Re: Submittals for Mary Kay Cooling Tower CC:

● **Comments:** Steve: Following backflow preventer, water meter and vault submittal is for your review. Please advise if you need anything else.

05 BACKFLOW PREVENTER DETAIL
NOT TO SCALE

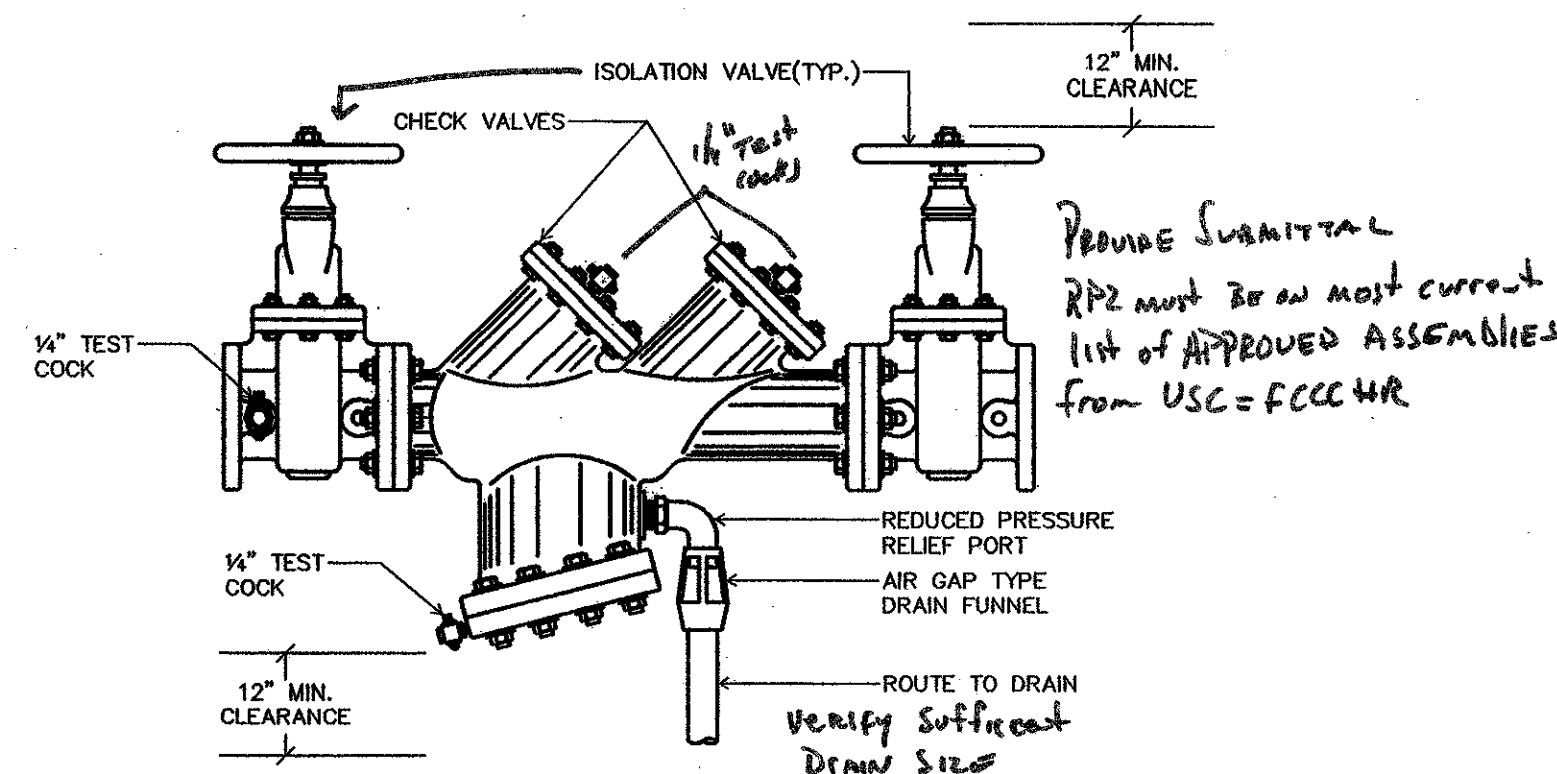
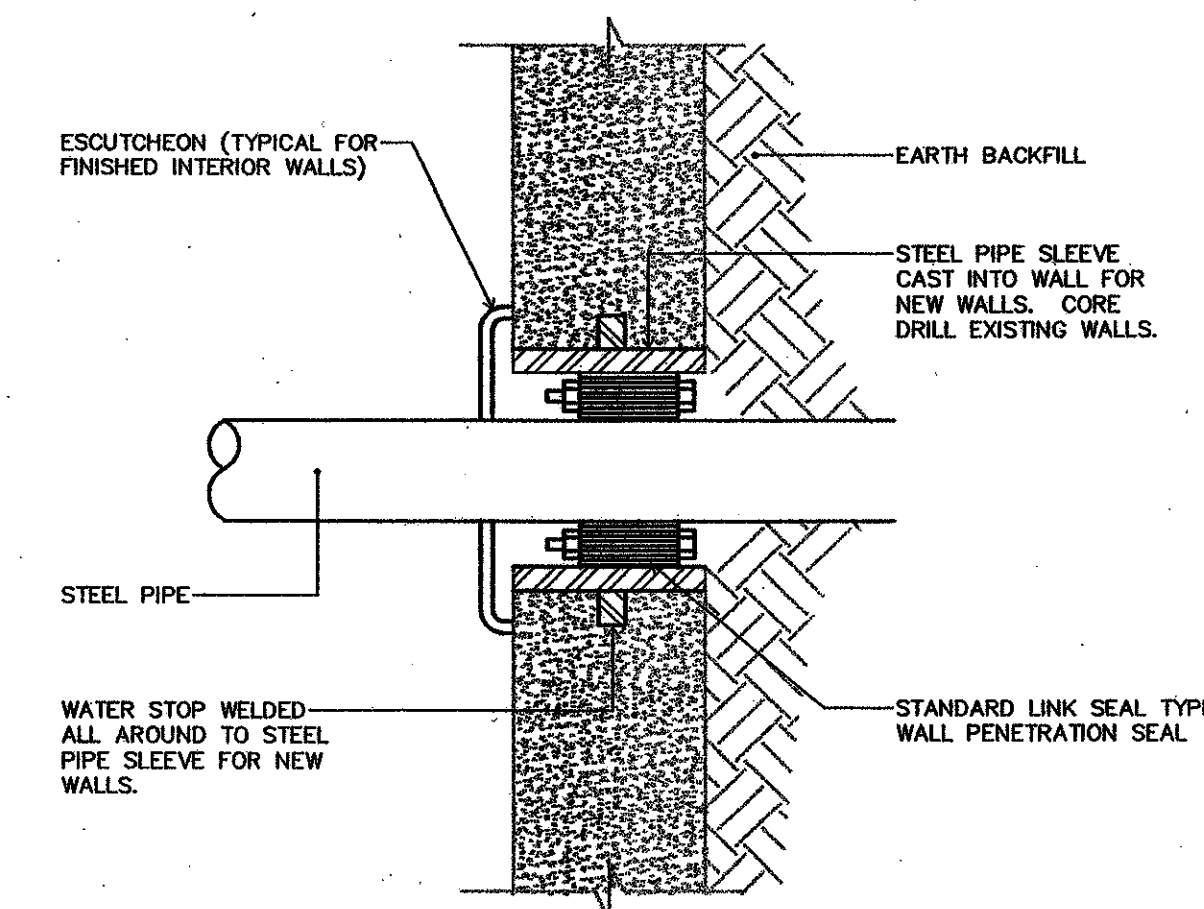
Need Redwood Pressure

Principle ~~DETECTOR~~ Assembly

Cobrao Model # is ~~40-70C~~

Other 6" options ~~Ames 5000~~

Fake 826VD

Watts 009 NRS

Watts 909 RPD A

Submit meter spec to match with ours, Turbine bypass
water w/ electronic ancodor register with touch pads.
RALD 11/6/03
